RE: Review Comments
Willow Springs Ranch West Annexation

**Development Review Comments
Willow Springs Ranch West**

Date: Tuesday, November 18, 2025
To: Town of Monument Planning Department
Attn: Rey Medina
From: Taylor Goertz, PE, IMEG
Shelley Cobau, CFM, IMEG
RE: Willow Springs Annexation, Submittal 1

WILLOW SPRINGS ANNEXATION No. 3
CONCEPT PLAN

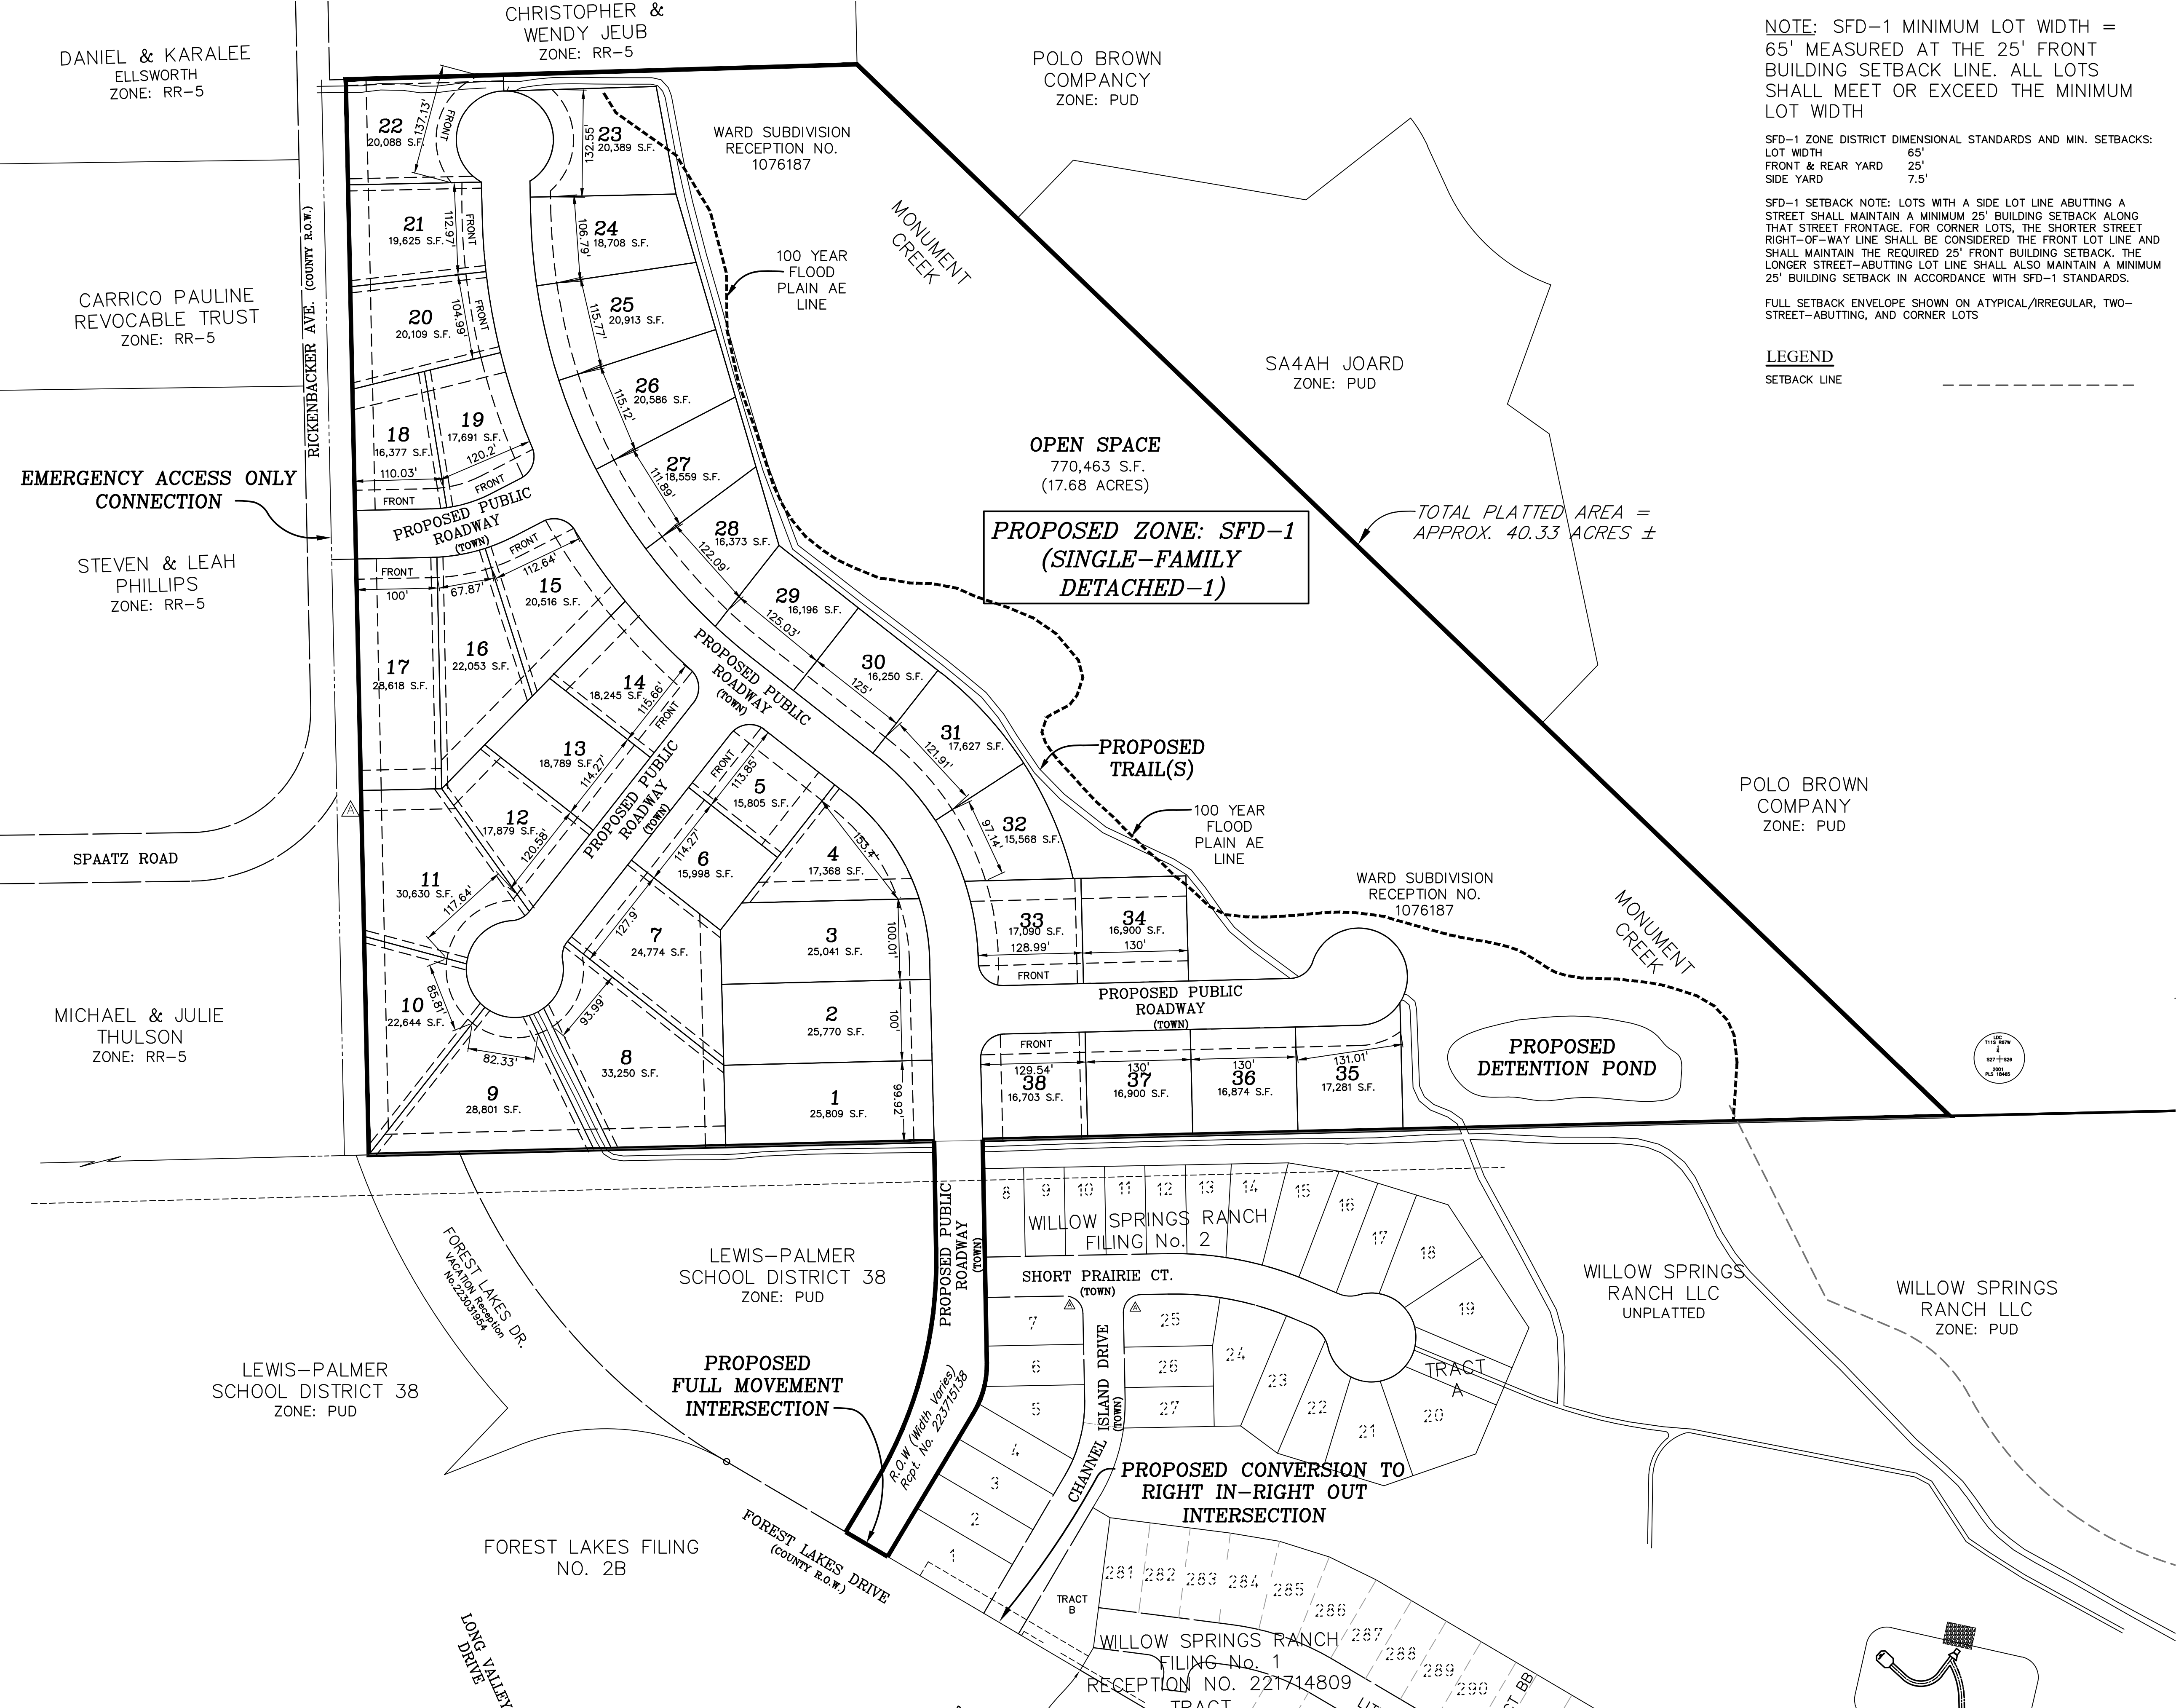
- a. All signatures and surveyor's professional seal must be provided on the Annexation Plat.
- b. Reference(s) to Willow Ranch Drive in the Pre-Annexation Narrative, must be corrected to Willow Ranch Road.
- c. Points of proposed connection for water and wastewater must be provided on the Conceptual Land Use Plan.
- d. The water dedication from the Polo Brown Company must be provided and the dedication signed on the Plat.
- e. Be advised that the lender of the Deed of Trust will need to sign off on this annexation.
- f. Correct the name of Willow Springs Ranch Filing No. 2 on Sheet 1, there appears to be a typo.
- g. The reference to the public right-of-way on the west side of Willow Springs Ranch Filing No. 2 needs to be made darker in order to be visible.
